May 14, 2013

**Re: Montano Transit Center, 130 and 138 Montano Rd NW,
Traffic Circulation Layout
Engineer's Stamp dated 5-08-13 (F15-D32)**

Based upon the information provided in your submittal received 5-08-13, the above referenced plan cannot be approved for Building Permit until the following comments are addressed:

Sheet No. C-003

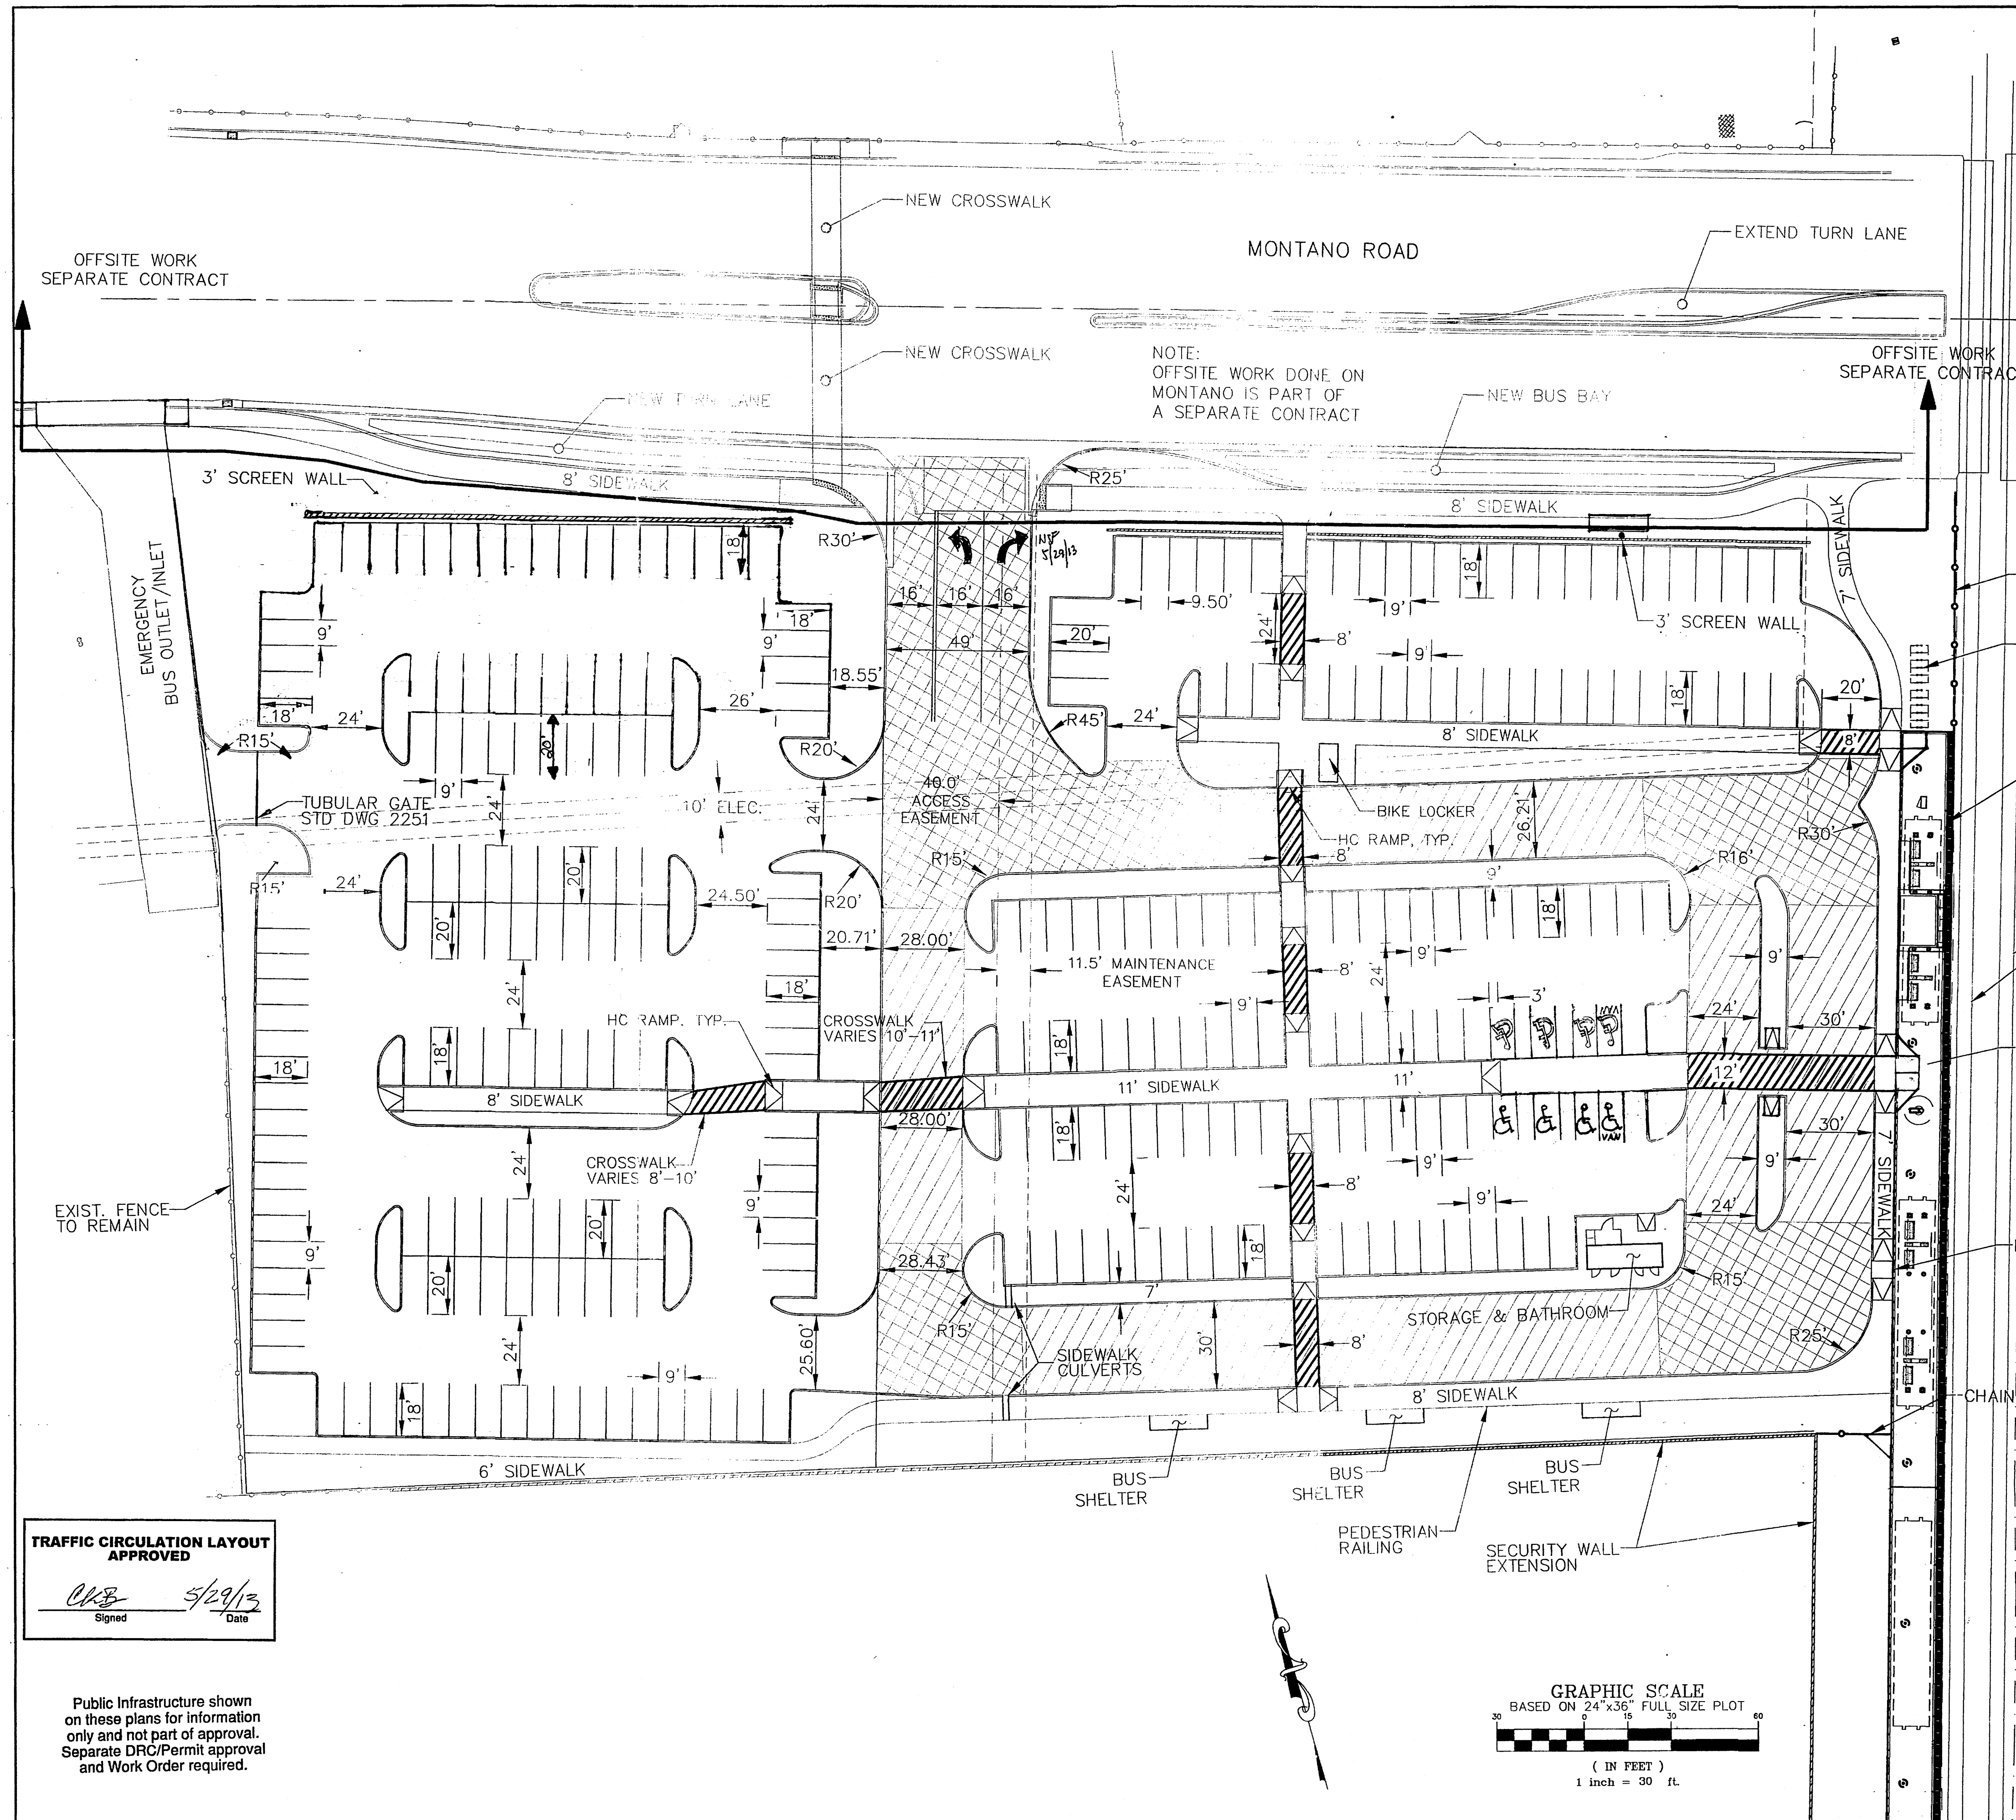
1. Please include two copies of the traffic circulation layout at the next submittal.
2. Please label the site plan "Traffic Circulation Layout" and note additional sheets if referenced in the TCL.

3. Please delineate between the work to be completed under the building permit and the offsite work done under a separate contract. Work within the public right of way requires a work order with DRC approved plans.

4. Please show a vicinity map on the TCL.
5. Please include the legal description of the site on the TCL.
6. Will the two lots be combined into one through a platting action at DRB? If not, a shared parking / access agreements will be required.

7. Please show and label all property lines, easements and agreements.
8. List the number of parking spaces required by the zoning code as well as the proposed number of parking spaces.

9. List radii on the TCL site plan for: curb return fronting Montano Rd., parking lot access point to emergency bus lane, and end islands adjacent to the turning path of large vehicles.

10. Please note that for passenger vehicles, the minimum end island radius is 15 feet. Please make corrections where the proposed radii are less than 15 feet.

11. Please list the width and length for all parking spaces. The handicap parking stalls and adjacent access aisles are not dimensioned. The handicapped spaces must be a minimum of 8.5 feet in width. The handicapped spaces must include an 8-foot wide van access aisle; all other aisles should be 5 feet in width.

12. Please provide ADA posted signage for all HC parking stalls.
13. Please note that parking stalls that rely on the curb to stop the vehicle wheels must factor in a two foot over-hang. Vehicle overhang must not encroach into the required width of pedestrian pathways. Please verify.

14. The Landscape Plan was not provided for review with this TCE submittal. Please add the following note: "Landscaping and signing will not interfere with clear sight requirements. Therefore, signs, walls, trees, and shrubbery between 3 and 8 feet tall (as measured from the gutter pan) will not be acceptable in this area."

15. Entrances require pavement striping and arrows to define proper usage by entering and exiting vehicles. Please show and label pavement markings according to DPM standards.

16. Please clarify vehicle and bus movement through parking area. Provide signage and pavement markings to guide vehicles. Two-way movement requires a minimum of 24 feet. One-directional movement requires "Do Not Enter" and "One Way Only" signage and directional arrows marked on pavement.

17. There is a break in the line-type along the southern perimeter sidewalk, please clarify.
18. Please label width of striped crosswalks on asphalt between sidewalk connections.

19. Please provide detail of pedestrian railing.
20. Please clarify the pedestrian movement between the sidewalk, proposed platform and railroad tracks.

21. Please clarify why there is a handicap ramp located at the southern end of the 7 foot eastern sidewalk providing access to the bus drive aisle area.

22. Please refer to all applicable city standards.
23. Please ensure all ramps are ADA compliant.
24. Per the Development Process Manual, Chapter 27, Section 7, Part F.II, a scale of 1"=20' is recommended for sites of less than 5 acres.

25. A scale must be shown on the plan. Per the Development Process Manual, Chapter 27, Section 2, Part B.1, only the following scales may be used:
 - 1" = 50'

- 1" = 40'
 - 1" = 20'
 - 1" = 10'
 - 1" = 100' (for overall layouts only)
